Ref: HILR3002

## **RESPONSE TO CONSULTEE COMMENTS**

### **LAND NORTH OF 66 AND ADJACENT WATER EATON LANE, GOSFORD**

With respect to the current application ref. 22/03883/F, we have prepared this letter in response to comments received from statutory consultees, raised in relation to the proposed development of 96 dwellings at the site Land adjacent to Water Eaton Lane, Gosford. This submission focuses on technical matters raised and therefore elements related to wider design matters are not addressed at this stage.

# Bin Store 01

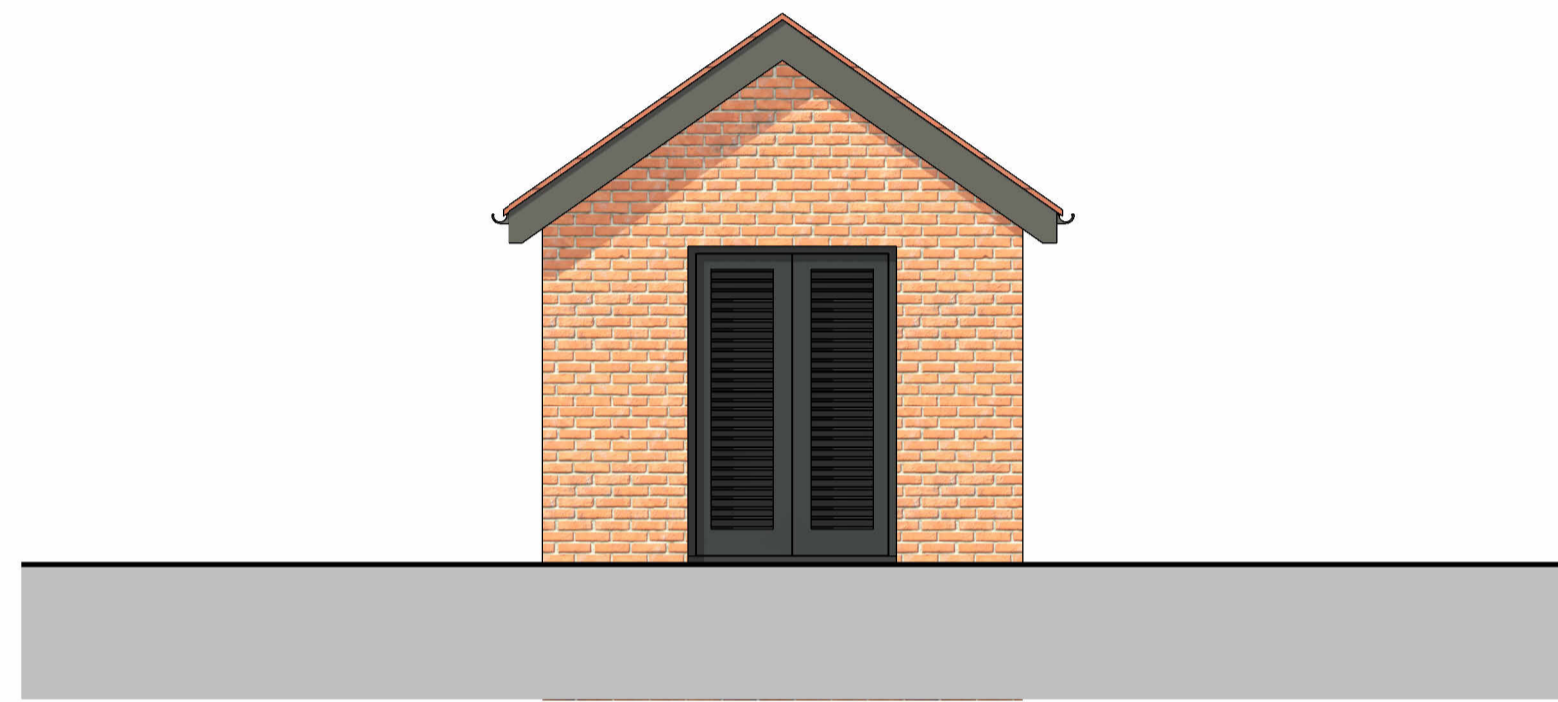
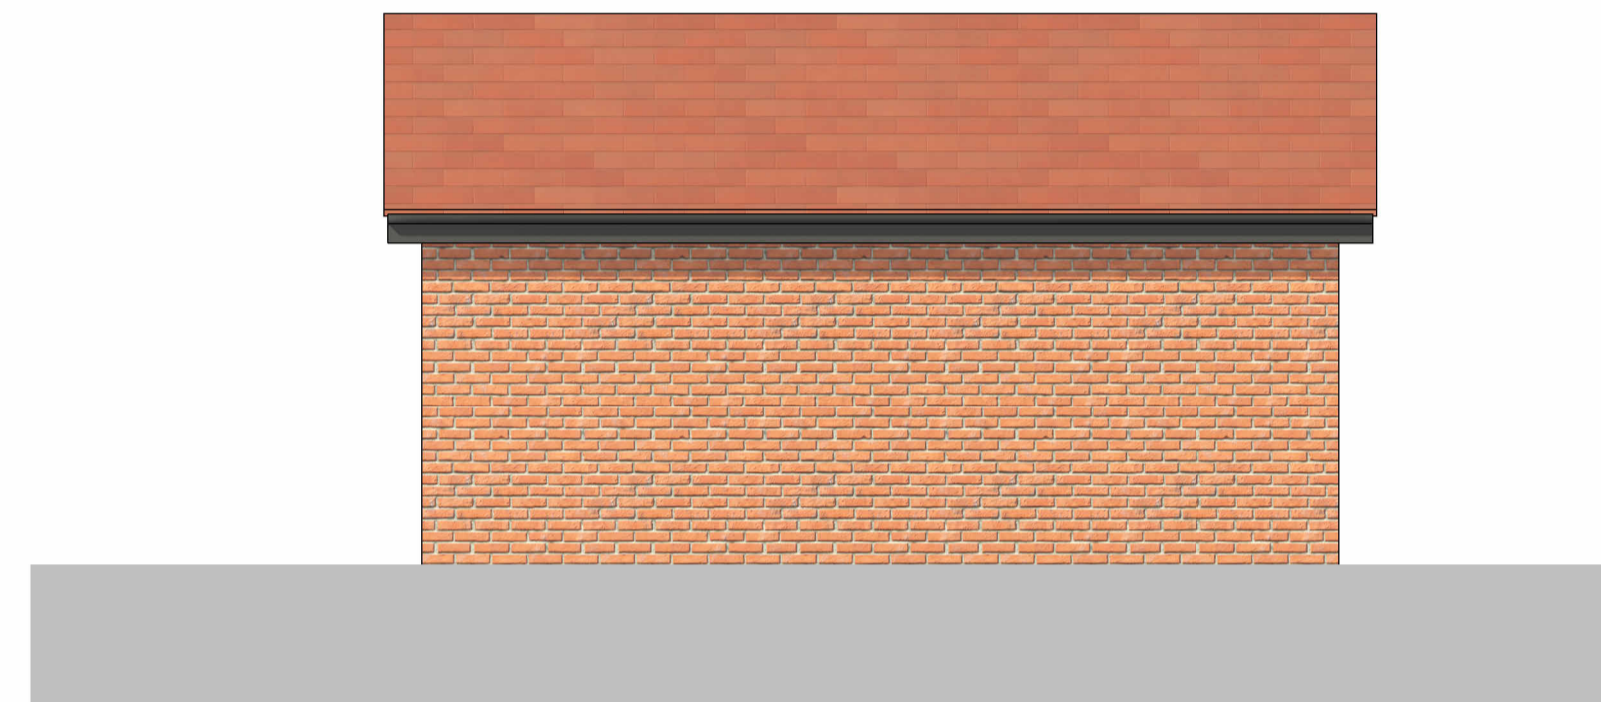
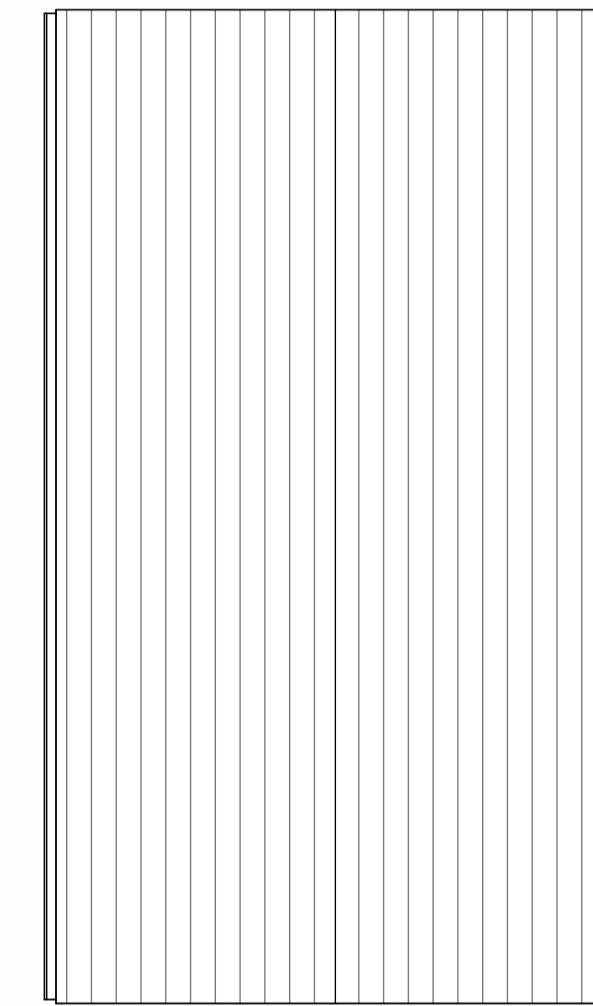
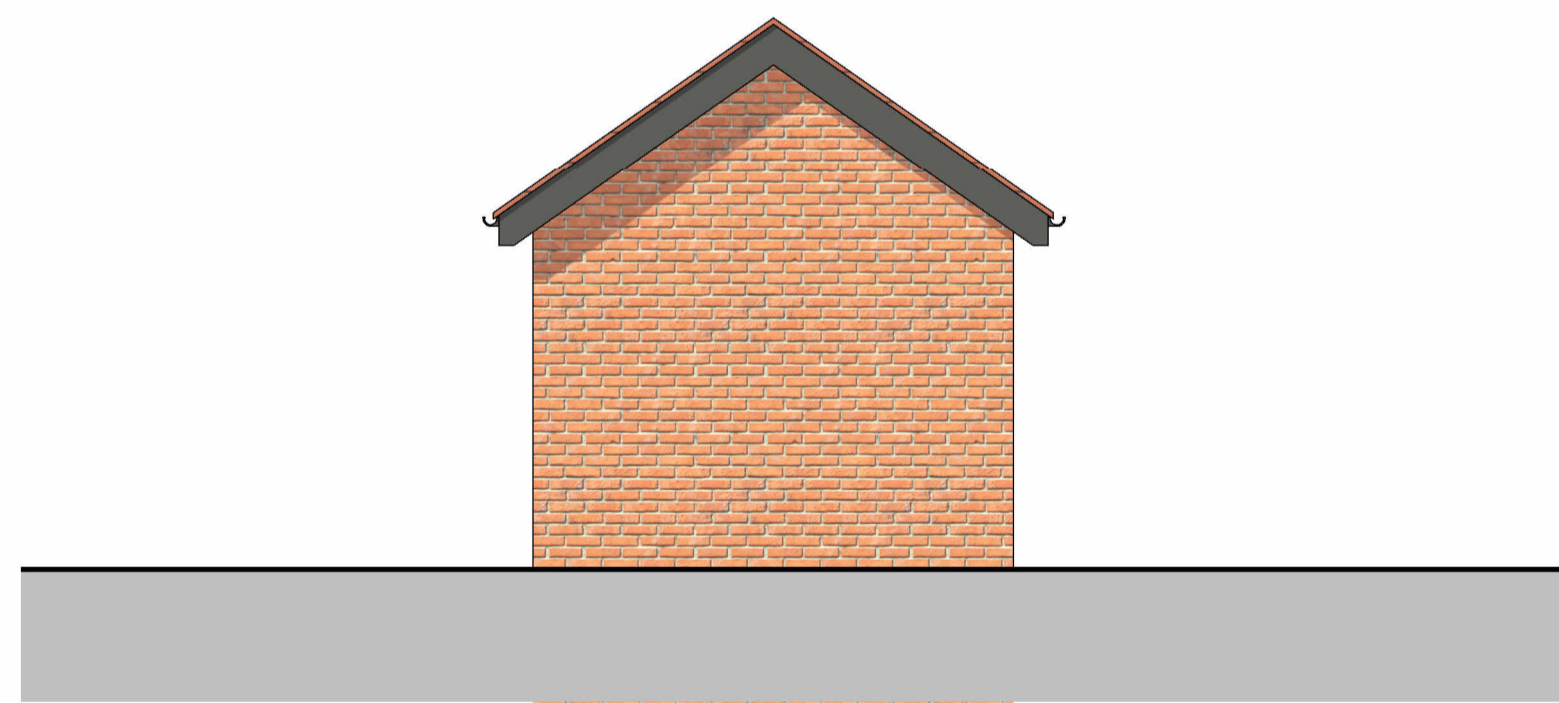
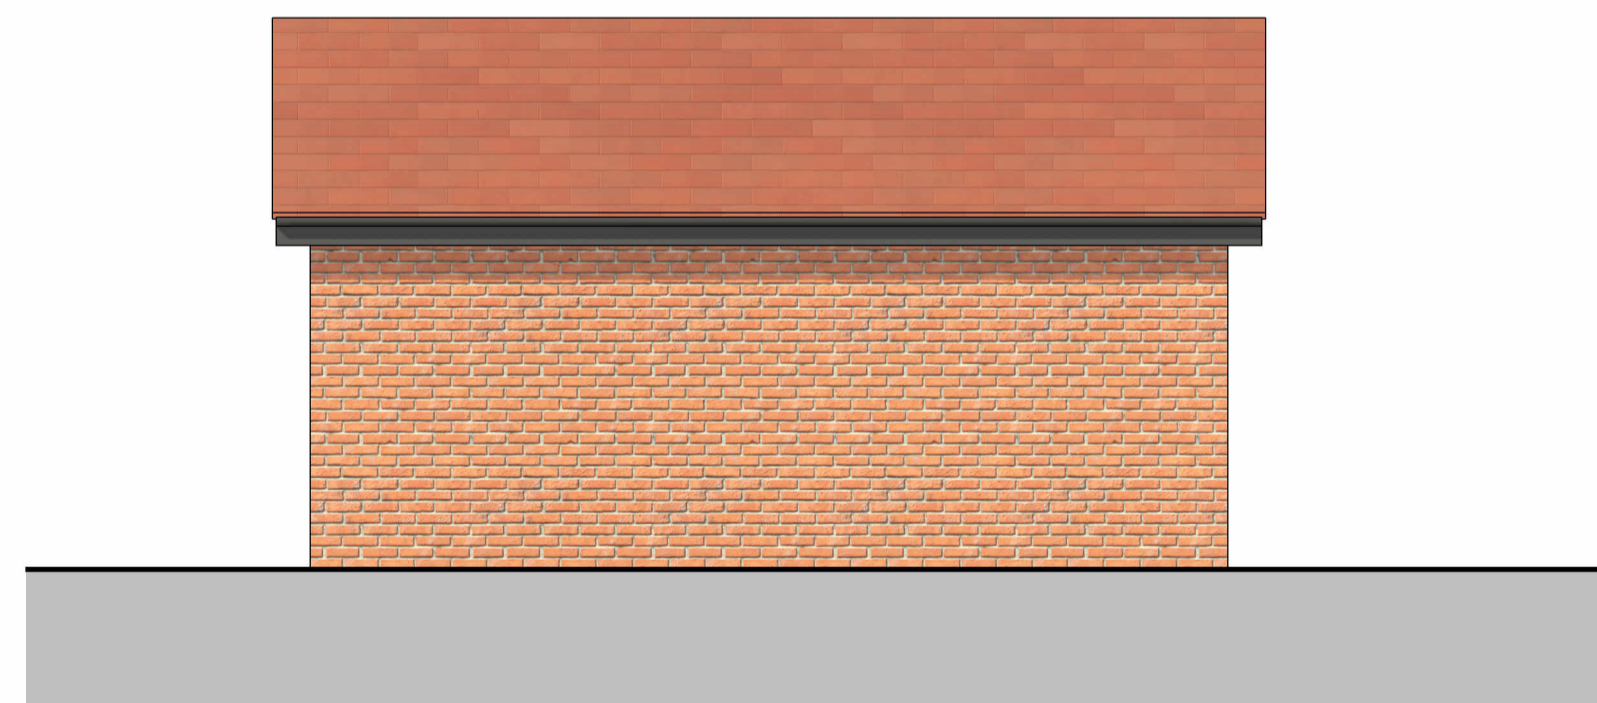
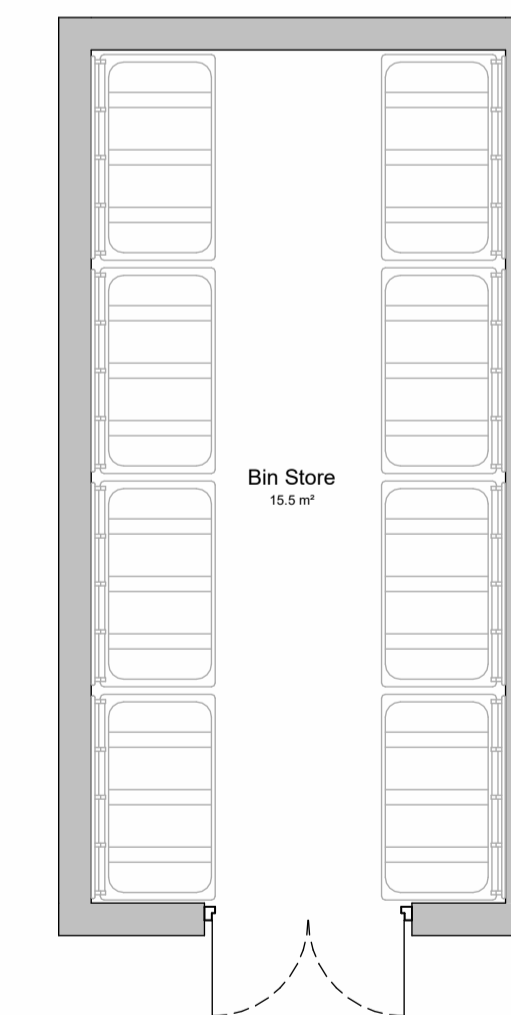
With regards to the apartments, the communal cycle storage is provided within each apartment building, at the ground floor. The southern block also includes an external cycle store which is accessible via a separate cycle store entrance door which will include a code locked system with the code issued to the allocated flats within the southern block only. It is also confirmed that the internal communal bin stores will be robustly secured with a

single leaf door to a minimum standard of LPS 1175 SR1 or equivalent. The annotated plan provided by the Crime Prevention Design Advisor suggests there is a cycle store located to the south of the apartment block, adjacent to the cemetery extension, to clarify, this building is a substation and a majority of the cycle storage is included within the apartment blocks, with only 9 cycle spaces included within the bin store building in close proximity to the east of the southern apartment block.
